Bramford to Twinstead Reinforcement

Document 8.11.3: Applicant's Comments on Other Submissions Received at Deadline 8

Final Issue A
February 2024

Planning Inspectorate Reference: EN020002

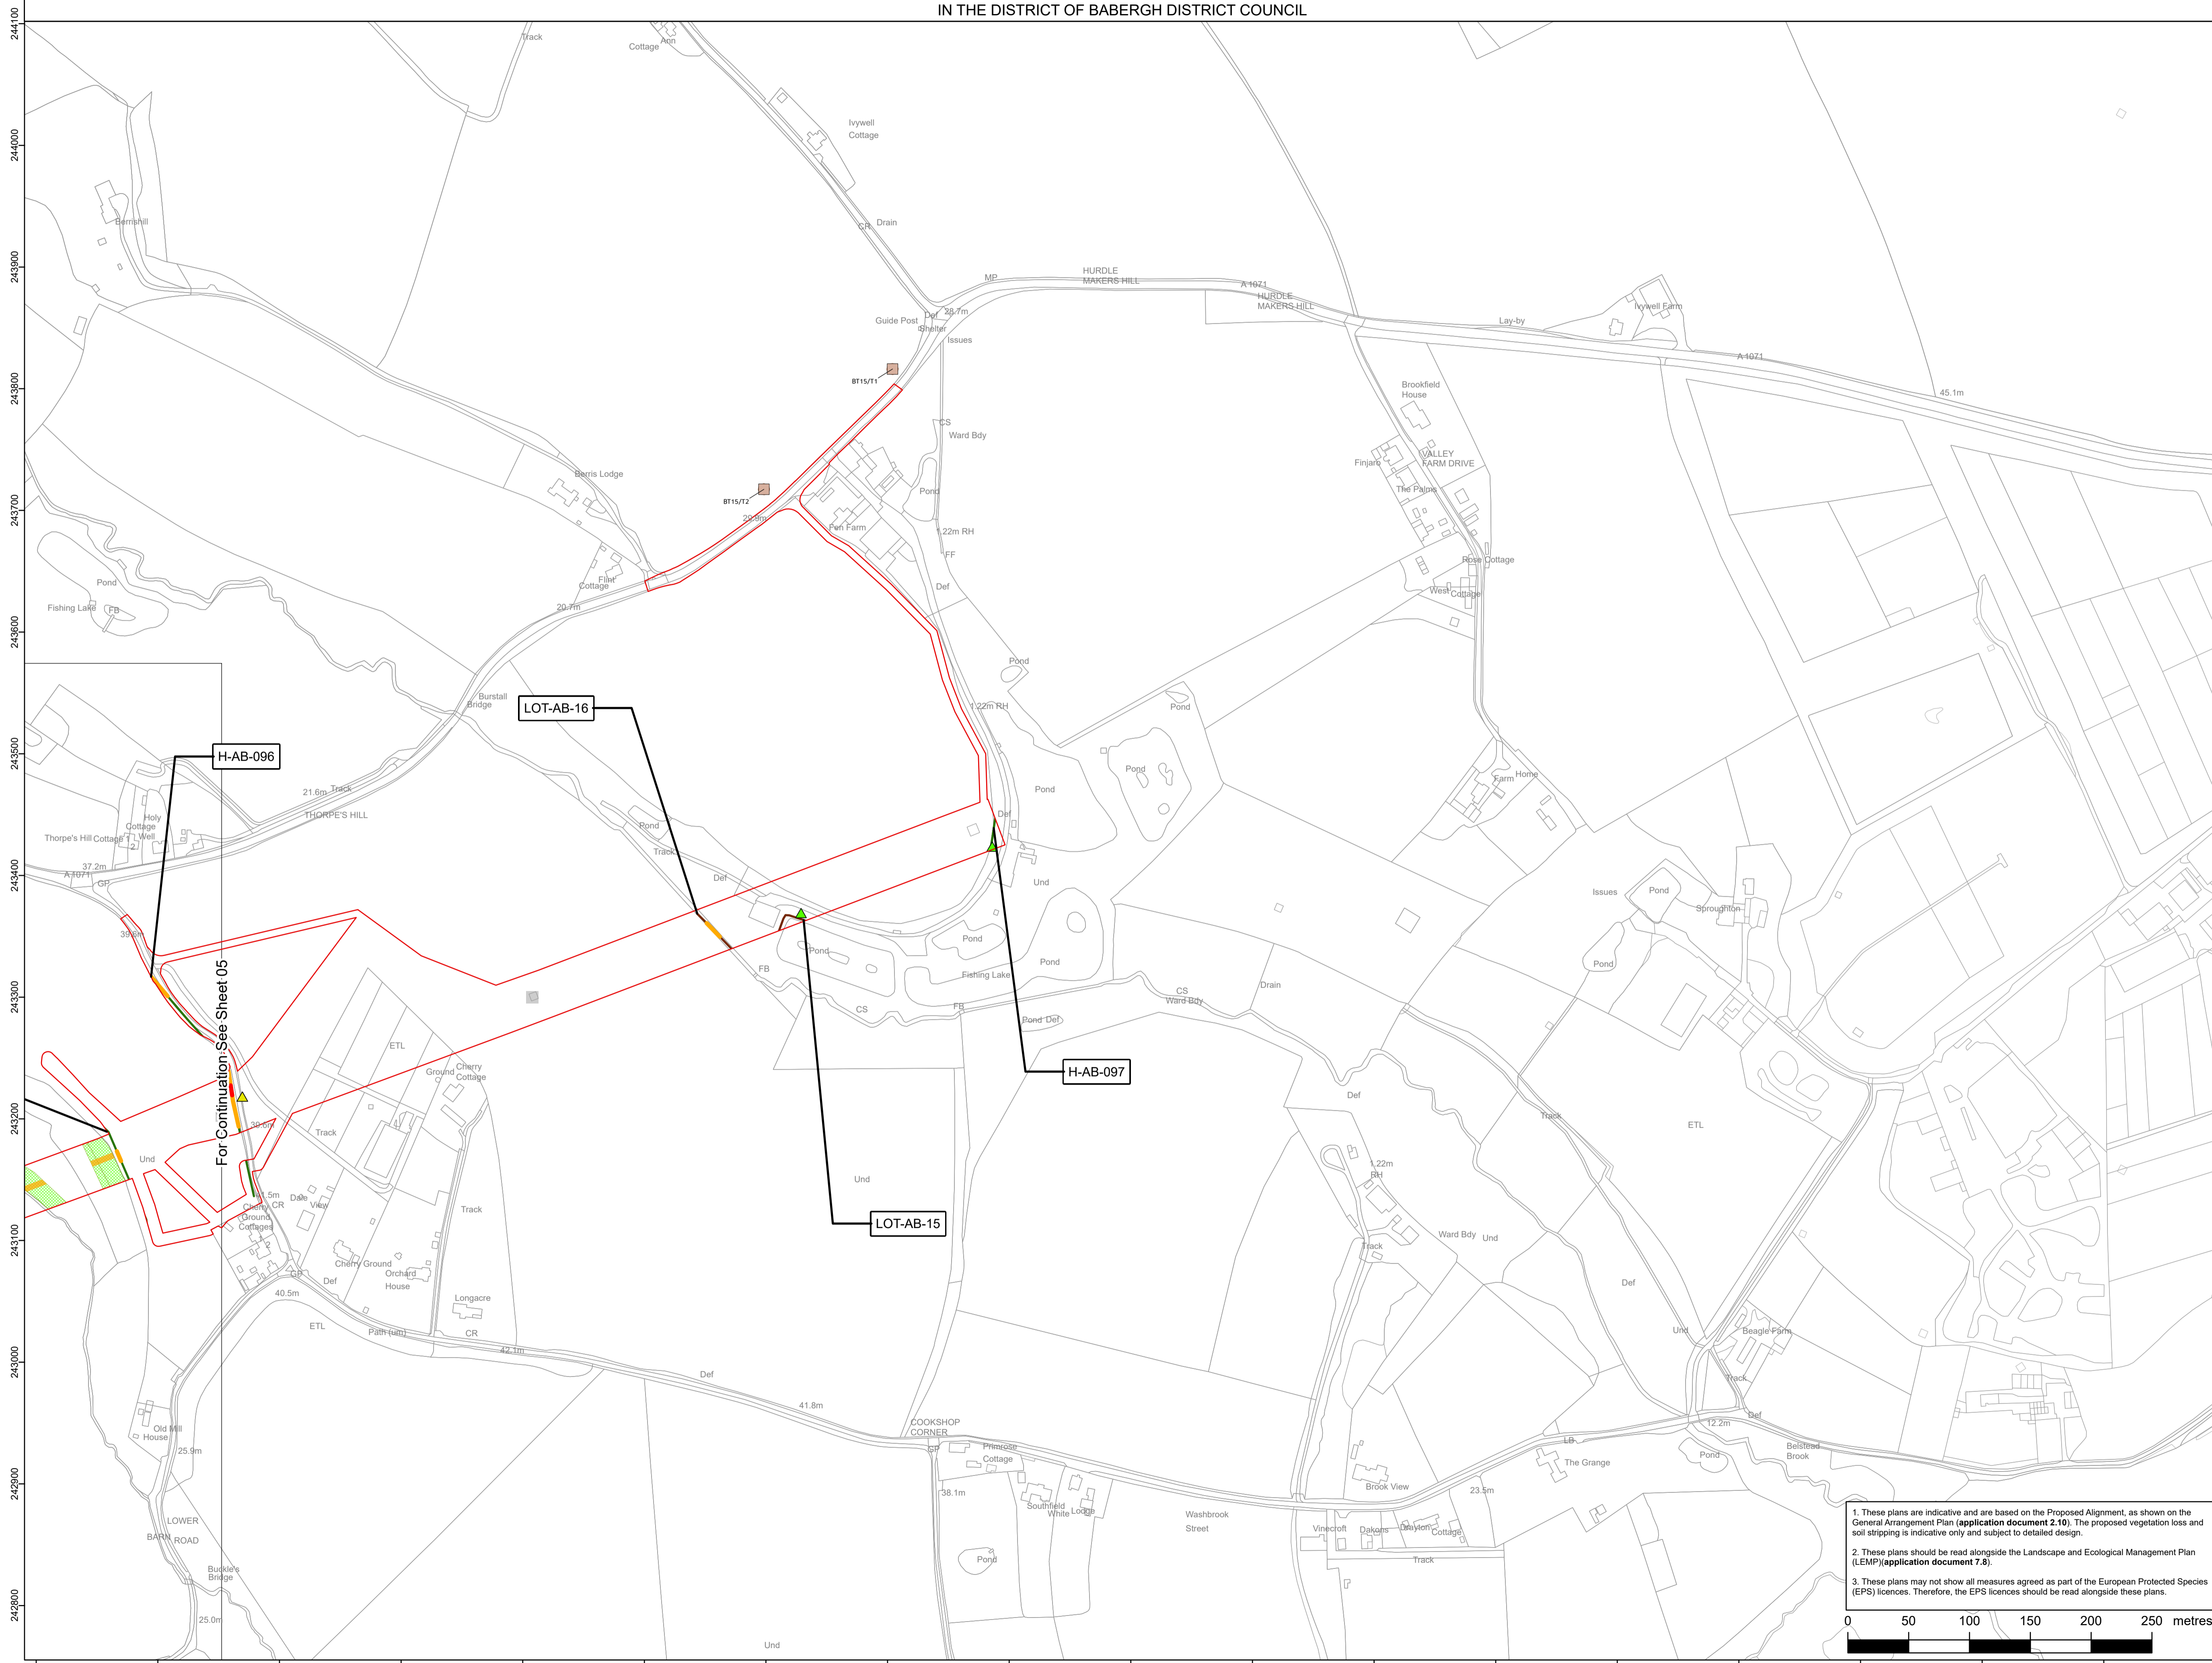
2b	EM-AB16 (Sheet 06)	Still shown on Sheet 10 to be topsoil stripped, while LEMP states that it will not be stripped, to avoid impact to the root protection area of the ancient woodland of Keeble Grove.	The Applicant has updated LEMP Appendix A (Document 7.8.1 (C)) and LEMP Appendix B (Document 7.8.2 (D)) at Deadline 9 to correct this error.
